# CITY OF ALBUQUERQUE

September 22, 2016

**Re: Guardian Storage- Summer Ridge and Unser  
Erosion and Sediment Control Plan  
Engineer's Stamp Date 8-8-16 (A11E015)**

Erosion Sediment Control Plan

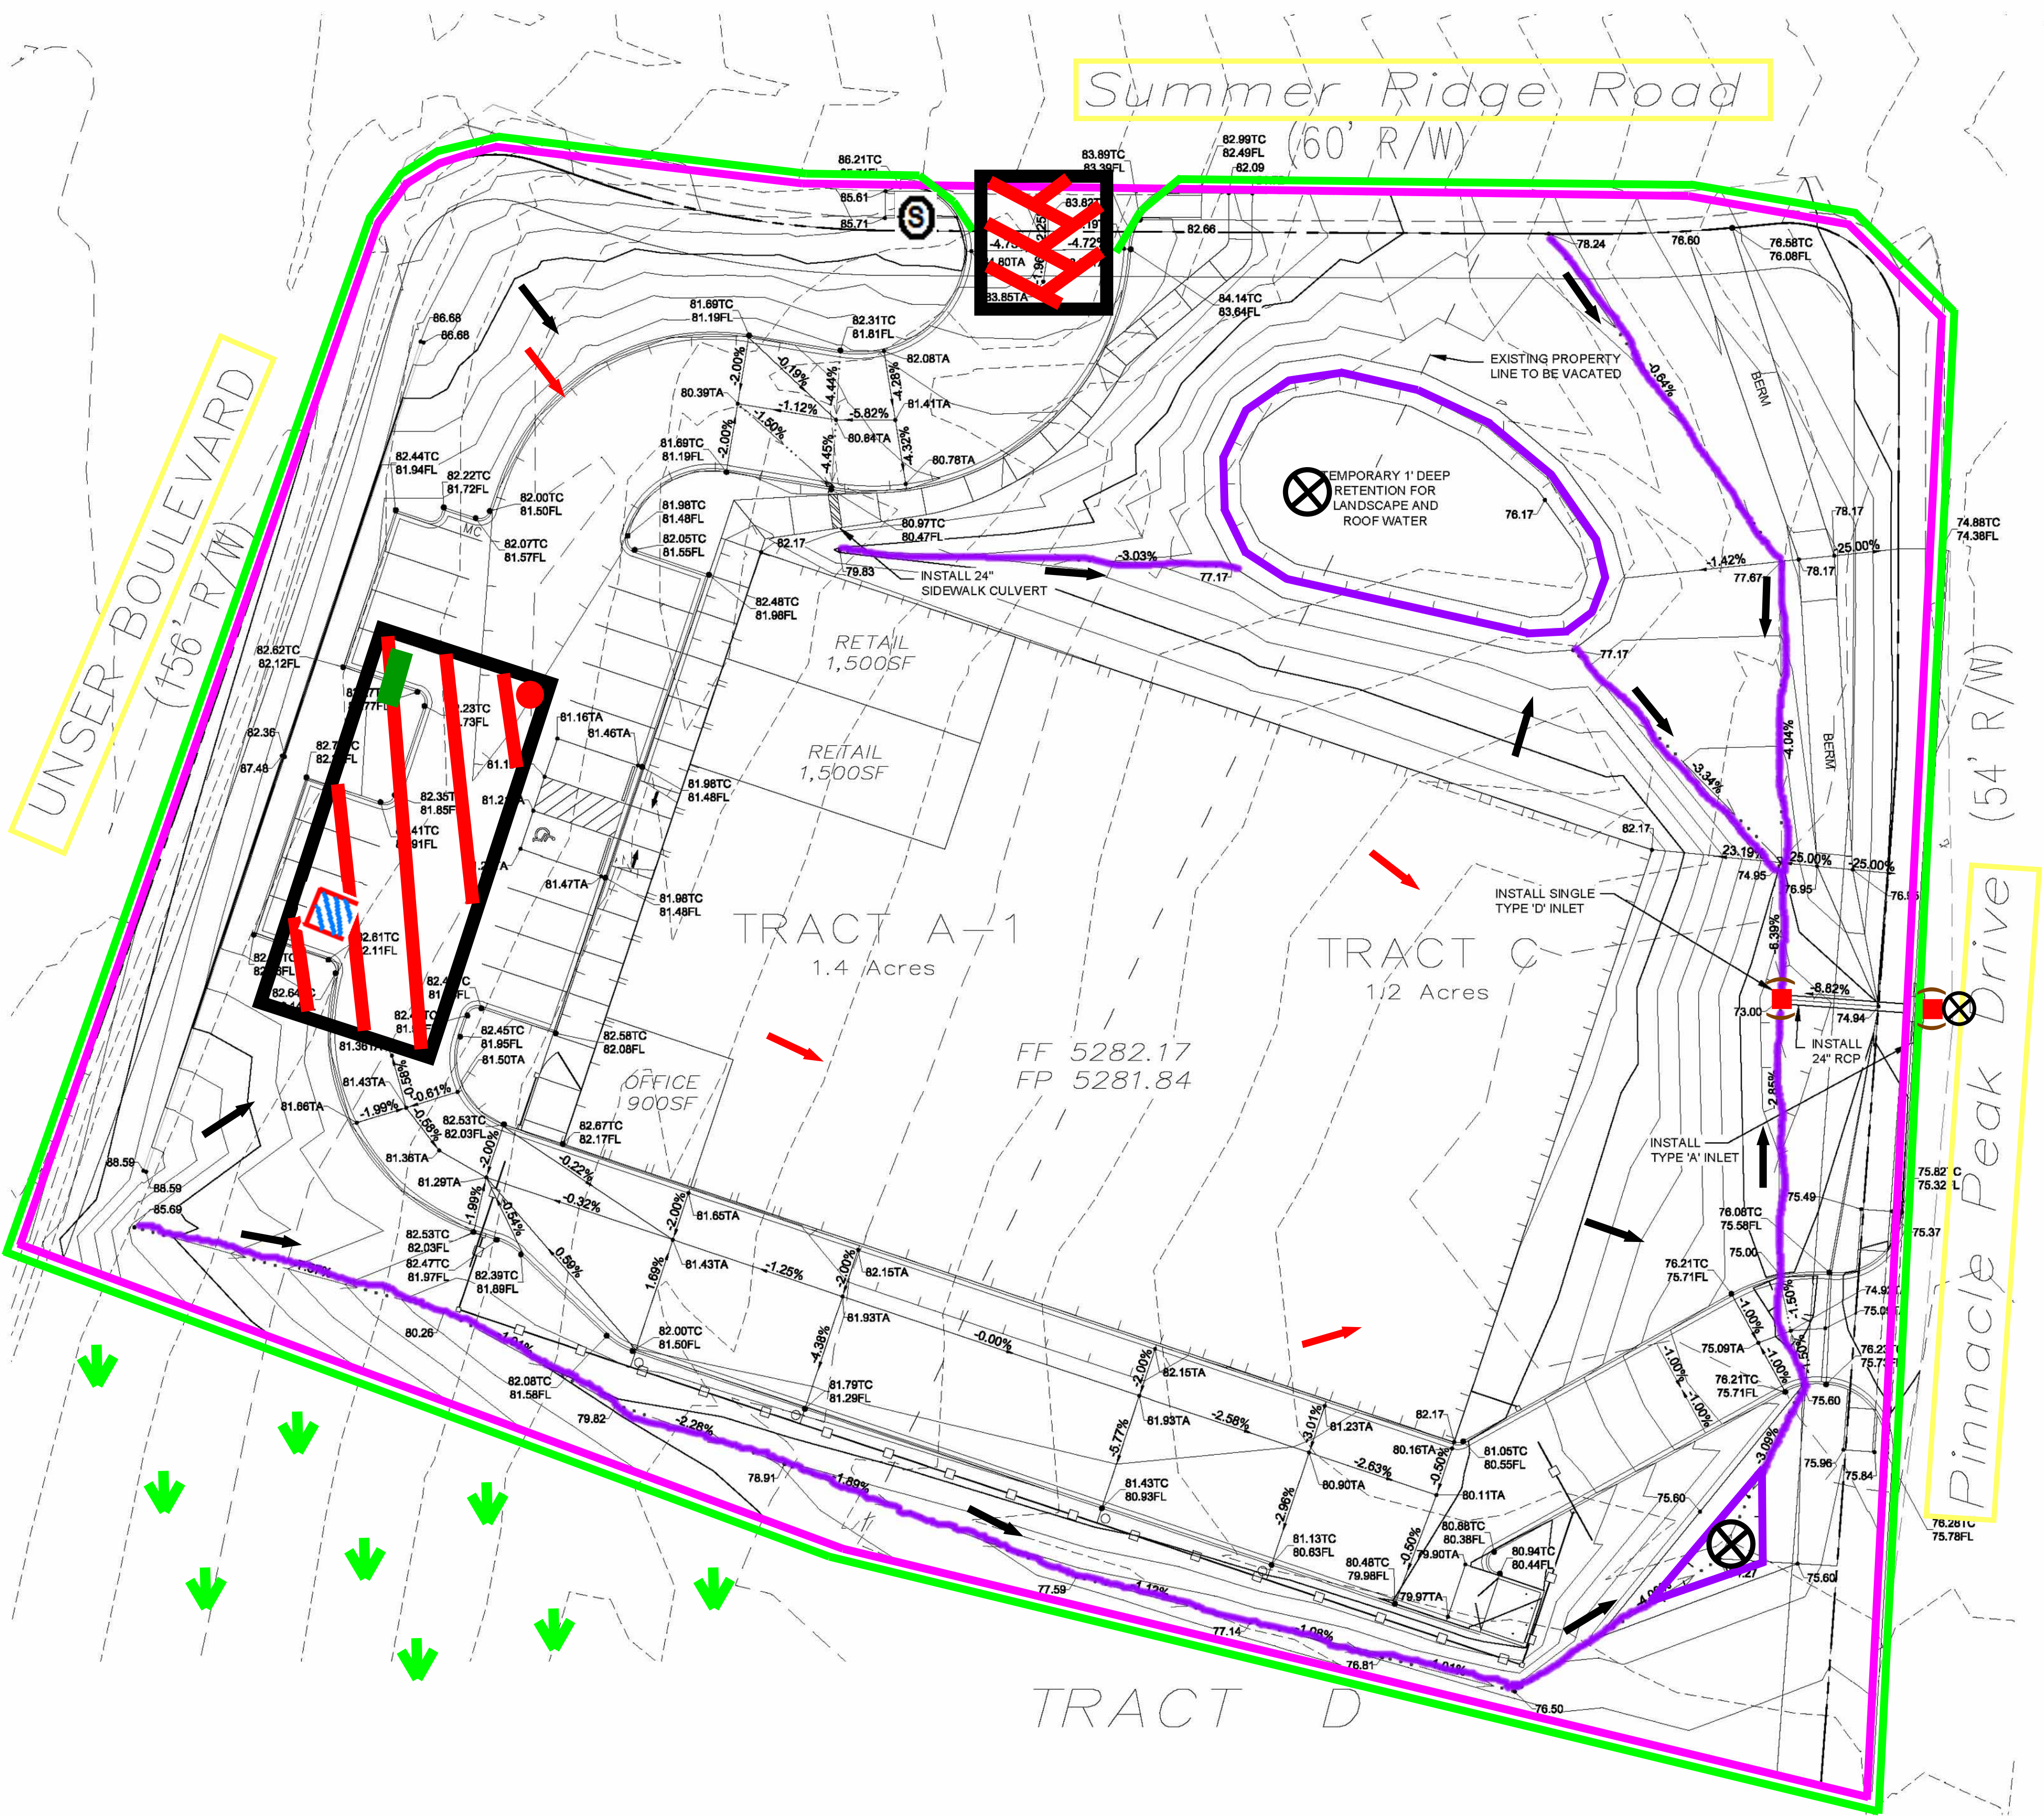
Provide applicable sheets (paving, utilities) from the Work Order Construction plans so that Stormwater Quality can evaluate the ESC plan for inclusion into this plan set.
